CITY OF ALBUQUERQUE

August 5, 2015

**Re: Dreamstyle Warehouse, 1525 Renaissance
Grading and Drainage Plan
Engineer's Stamp Date 7-21-2015 (F16-D051A)**

DRAWN BY
BJF
DATE
06/20/15
2015009-GRB
SHEET #
D2
JOB #
2015009

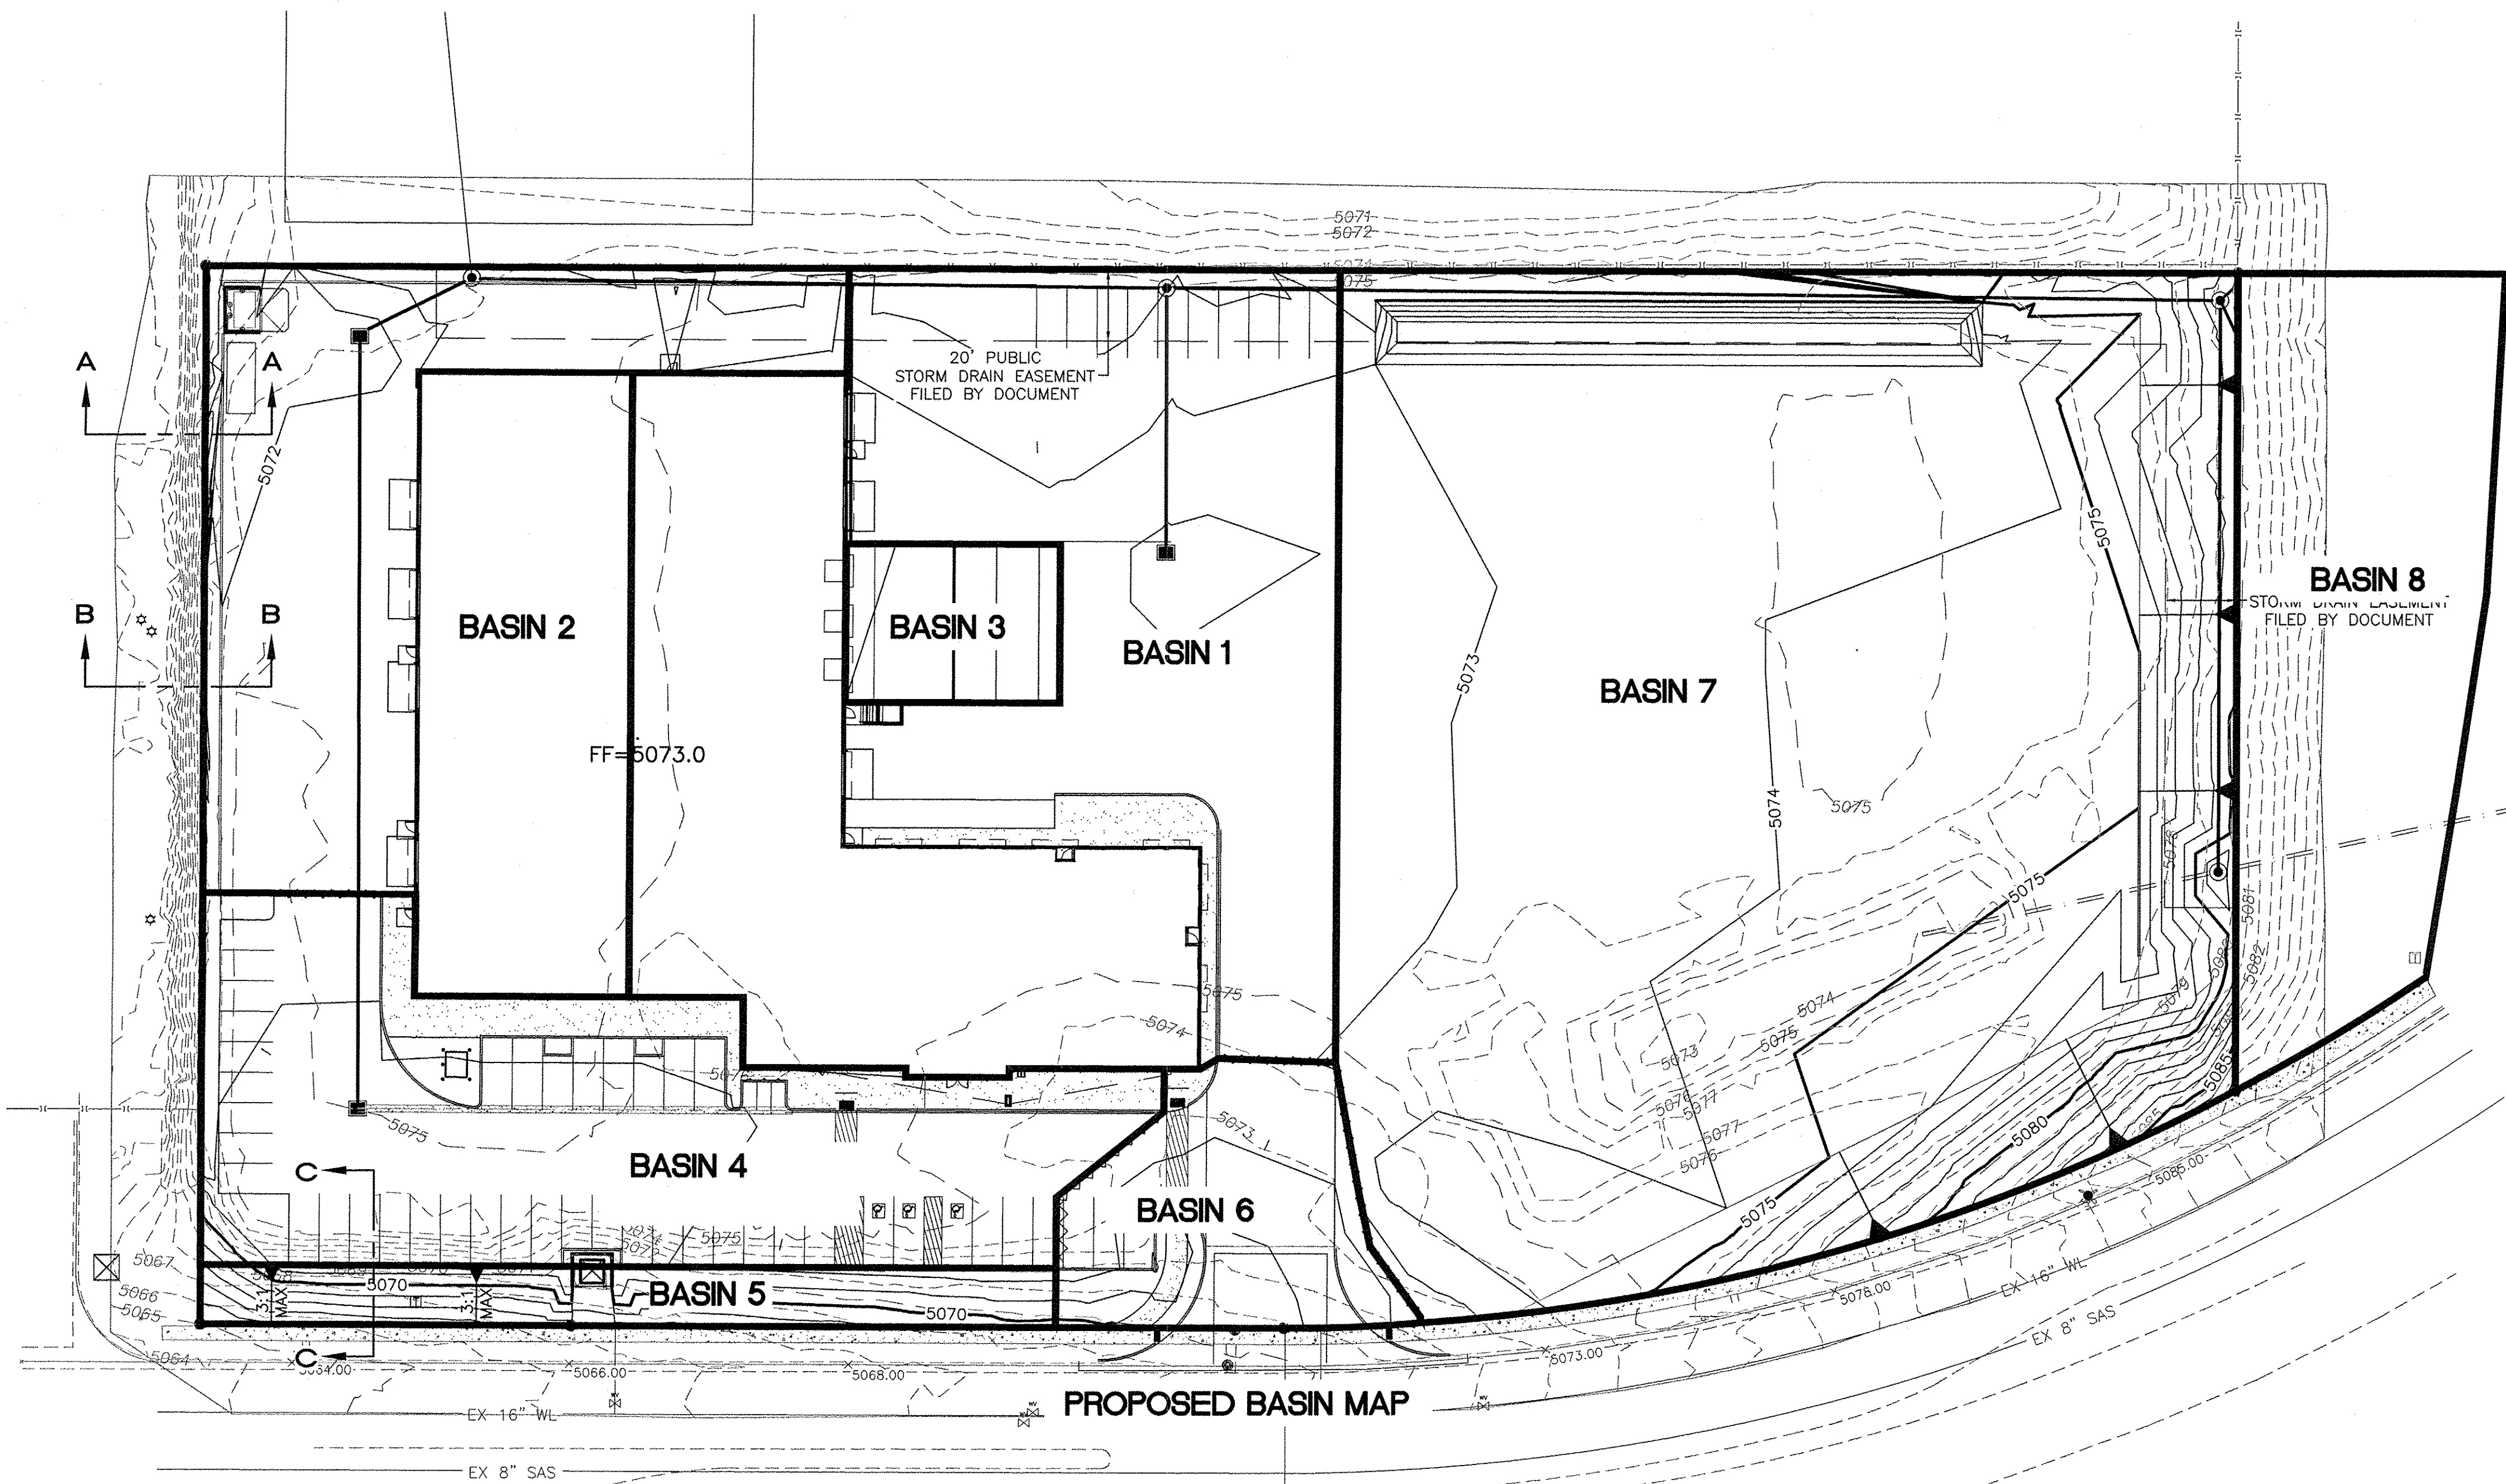
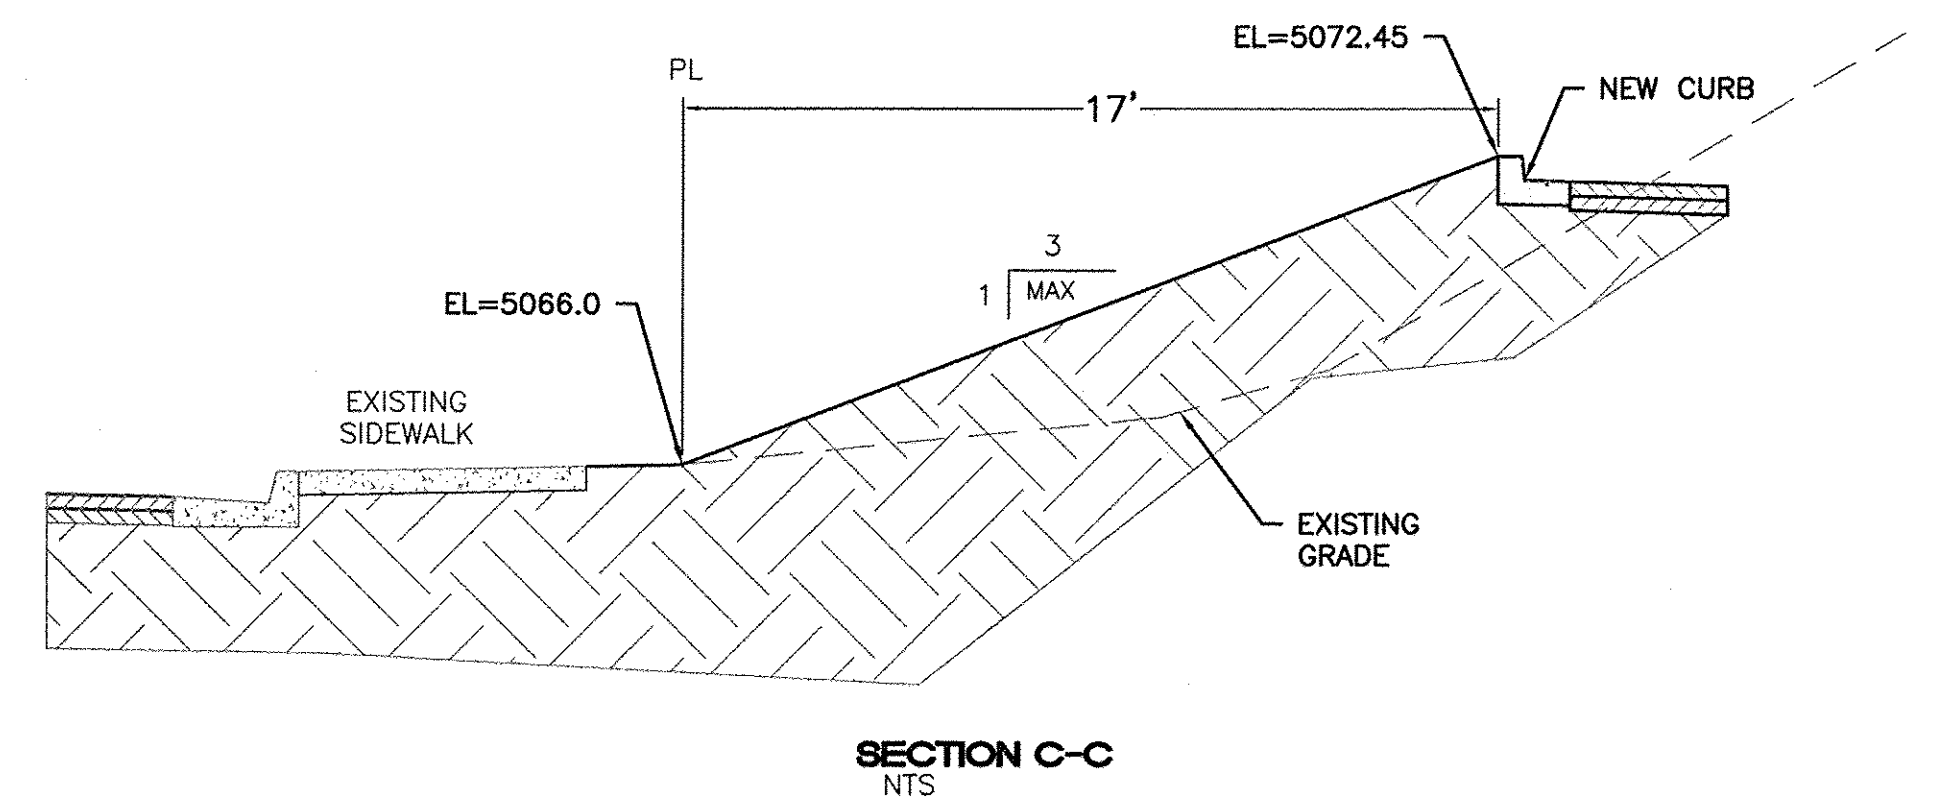
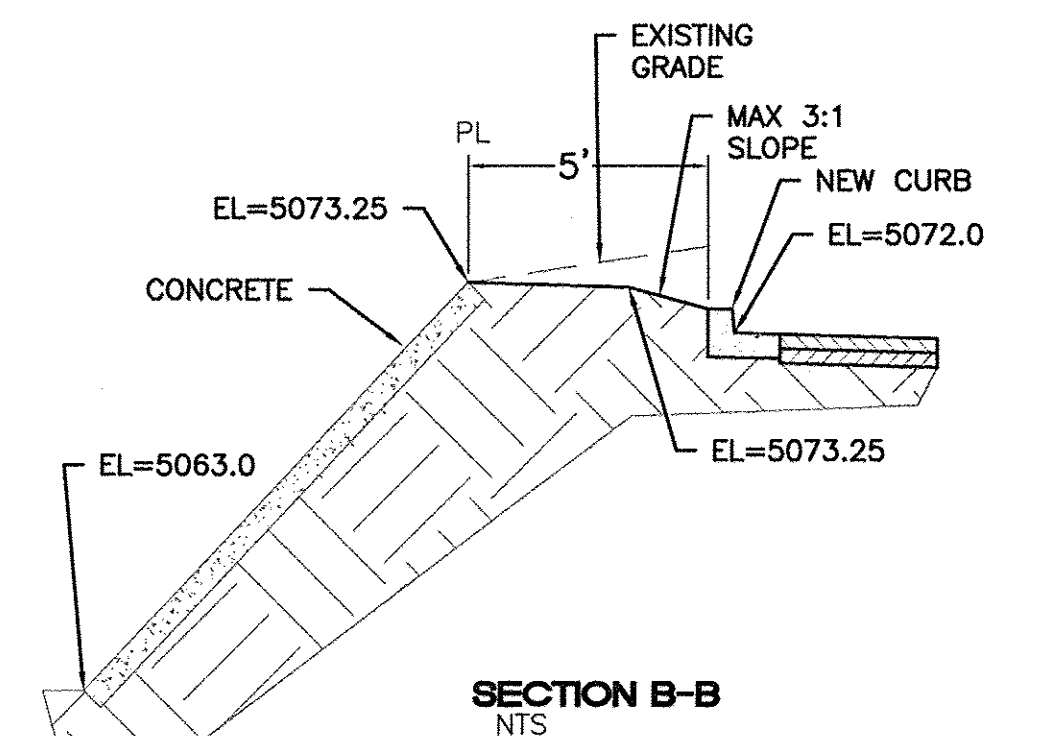
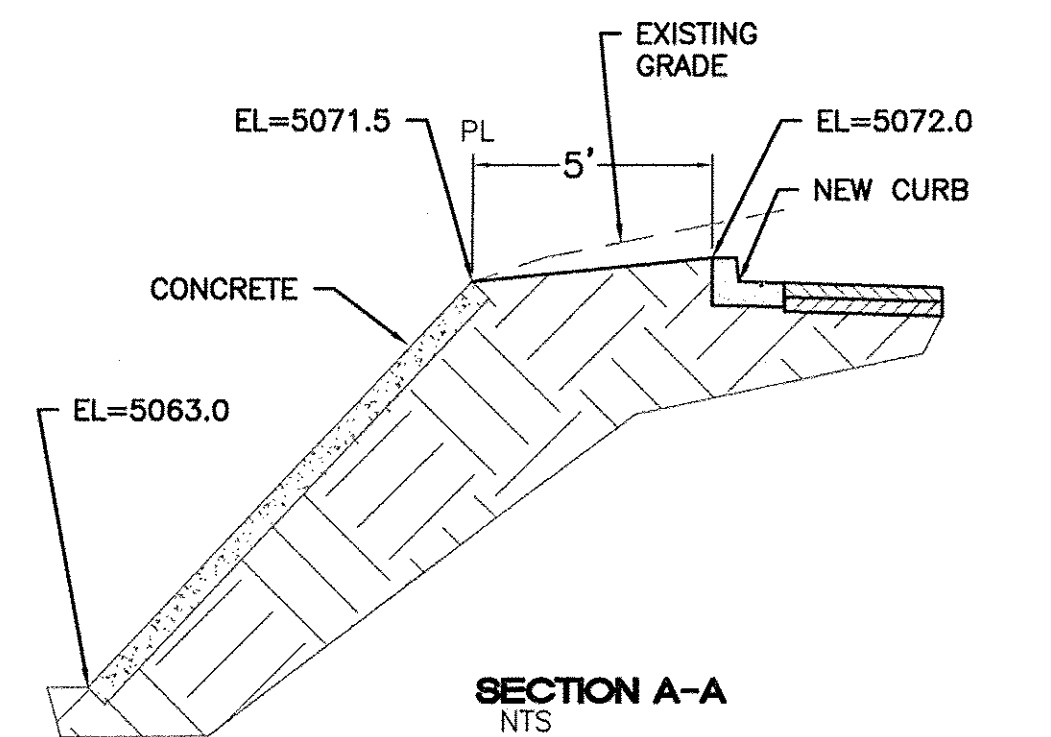
- A recorded "Drainage Easement" for the conveyance of offsite runoff via storm drain pipe across this site will be required prior to Certification of Occupancy.
